From: [Oliver, Lewis](#)
To: [Aquind Interconnector](#)
Subject: EN020022 - AQUIND Interconnector - Preliminary Meeting 8th September
Date: 01 September 2020 16:42:02
Attachments: [image001.png](#)
[AQUIND DCO HBC PCC HCC response to Issue 3 of PM \(002\).pdf](#)

**AQUIND Interconnector Examination Preliminary Meeting -
Havant Borough Council, Portsmouth City Council and Hampshire
County Council's response to Agenda Item 3 Initial Assessment of
Principal Alternatives**

**Plate 2.9 - DC Cable Route Options (Feb 2017)**

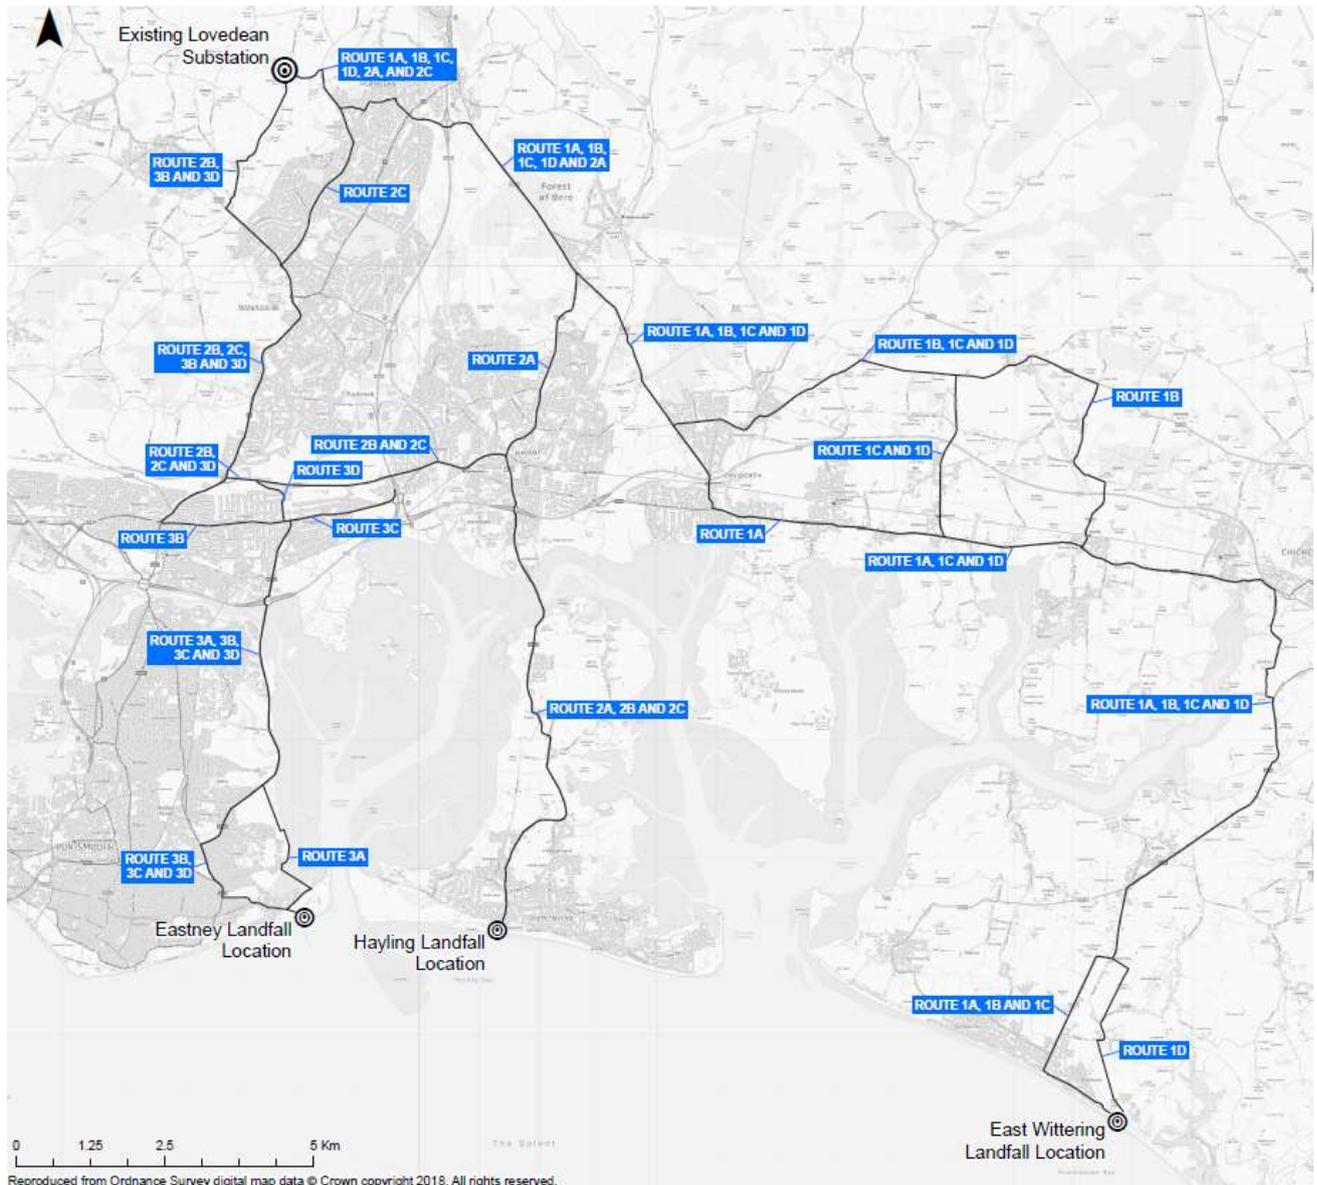
The routes from these landfall points to Lovedean are show on Plate 2.9 (DC Cable Route Options). They all show the cables being laid in the highway, emphasising the prior early decision taken by the applicant to utilise the road network and not appraise a cross-country route.

Section 2.4.11.5 does refer to consideration being given to shortening sections of the cable route by going off road across fields, but the primary approach was to look for routes following the road network. In the

assessment of the Eastney Portsea Island landfall to Lovedean option, no indication is given of the consideration of a cross-country route west of the A3.

**Plate 2.10 - Cable Route 3D (blue) and Cable Route 1D (pink)**

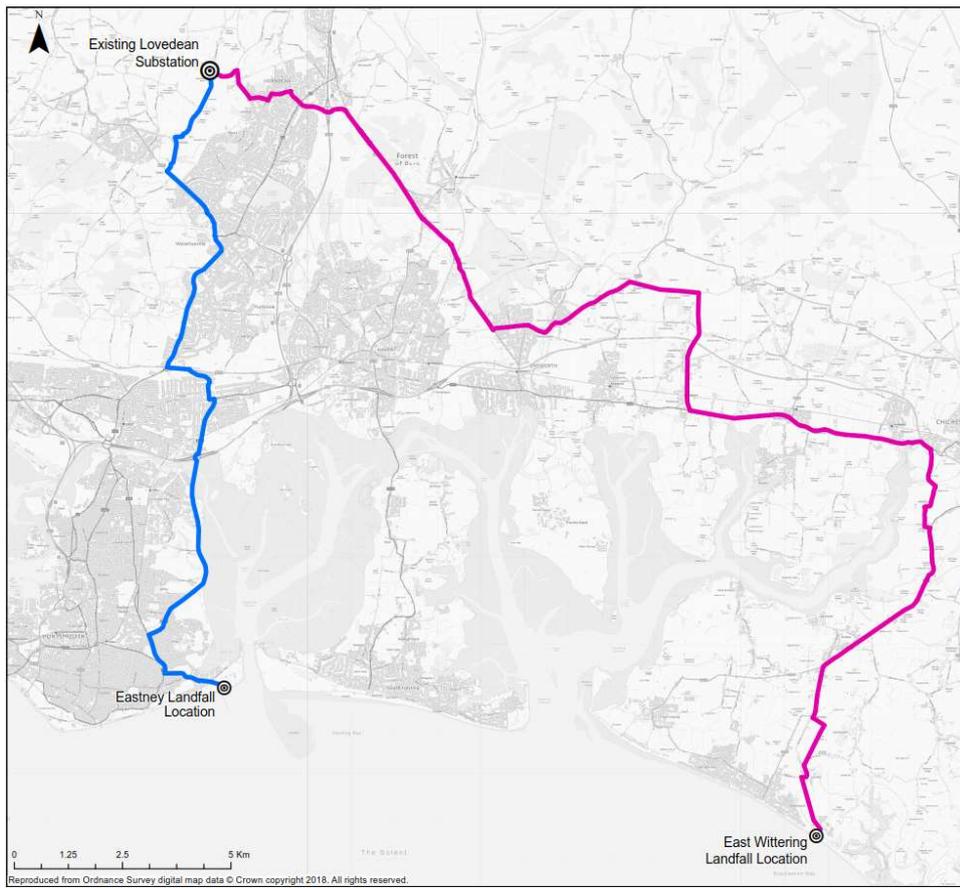
Section 2.4.13 (UK Cable Routes Detailed Desk Studies of Route 1D & 3D) June 2017 indicates that a further assessment of the Eastney to Lovedean cable route was made. The section makes no reference to the consideration of the cross-country route being assessed against the road route. Again, this appears to reflect the "strategic" choice made by the applicant.

**Plate 2.13 – Alternative Countryside Routes (as proposed by WCC and HBC)**

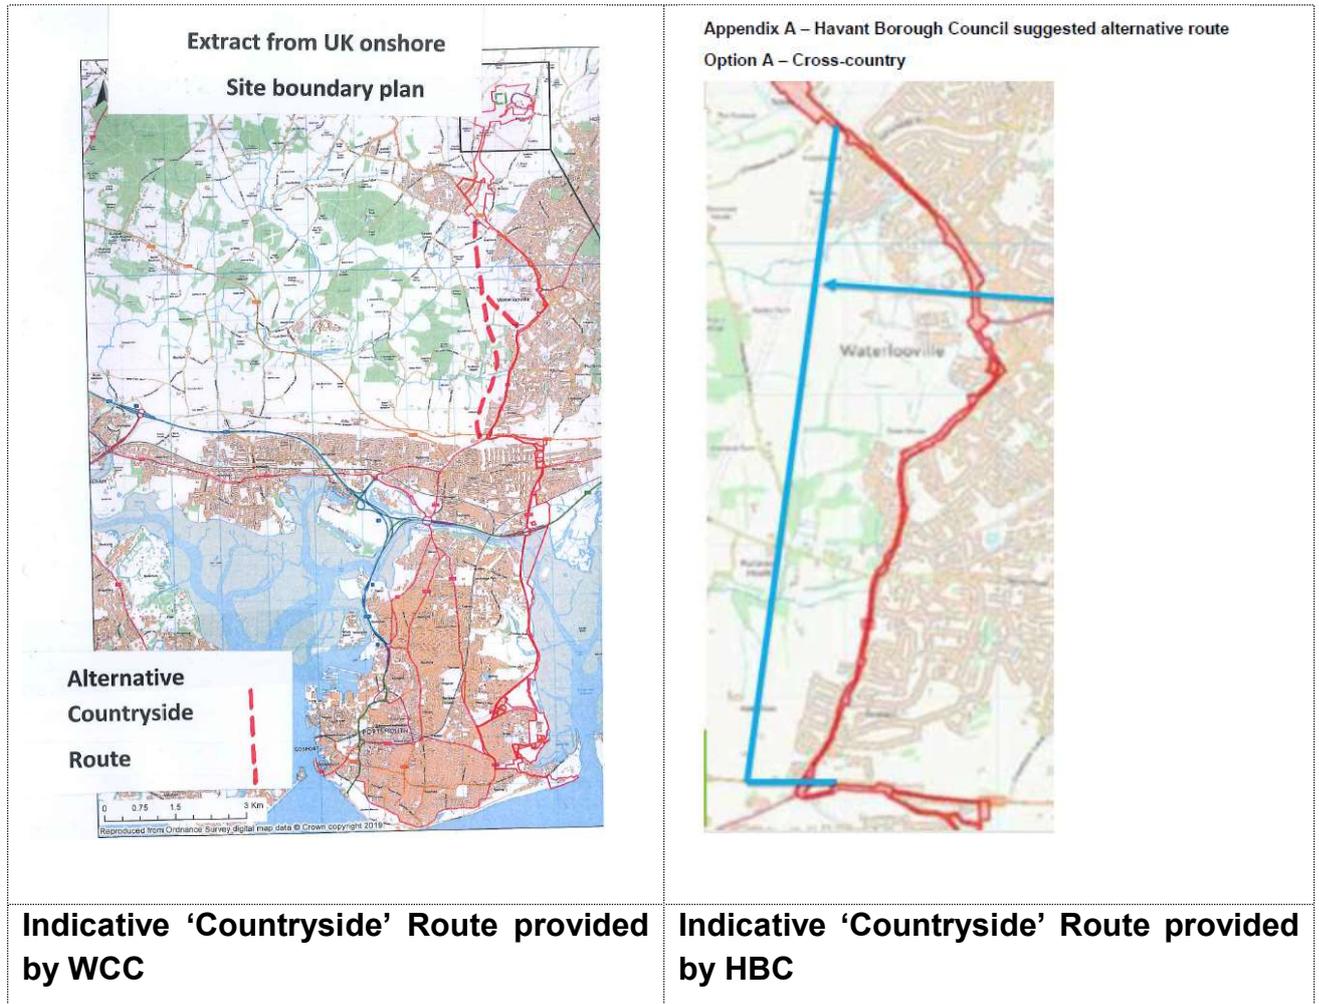
Section 2.6.4 outlines the response to the WCC and HBC Alternative Countryside Route which those authorities raised in their responses of April 2019 to the PEIR consultation exercise. Two comments are made in response to this section.

Firstly, this is the only point in the submission at which point the applicant addresses the cross-country route. The optioneering process is silent about any consideration of the cross-country route prior to this section. It seems likely that had the two councils not raised it in their responses to the PEIR then the ES may well have been totally devoid of any reference to it.

Secondly, the table as presented in 2.6.4 is not a fair assessment of the two options one against the other. It is not a straightforward process considering the environmental impacts of a countryside route compared to that following an urban route. The countryside option is highly likely to score higher on environmental impacts. What is lacking is a more detailed analysis beyond the simplistic observation that there will be some "temporary short-term impact on traffic" (2.6.4.5) if the road route is followed. Just as the Environmental impacts are listed in the table so the socio-economic impacts need identifying and weighing. These should include covering the potential delays to traffic including emergency vehicles and the potential to inhibit future work to maintain or enhance the road network or service future development through the presence of the cables in the road. Other impacts, such as the potential impact on highway trees have yet to be appraised. The fact the applicant has not explored these in a greater level of detail and that the level of impact is still emerging is viewed as a deficiency in the process.
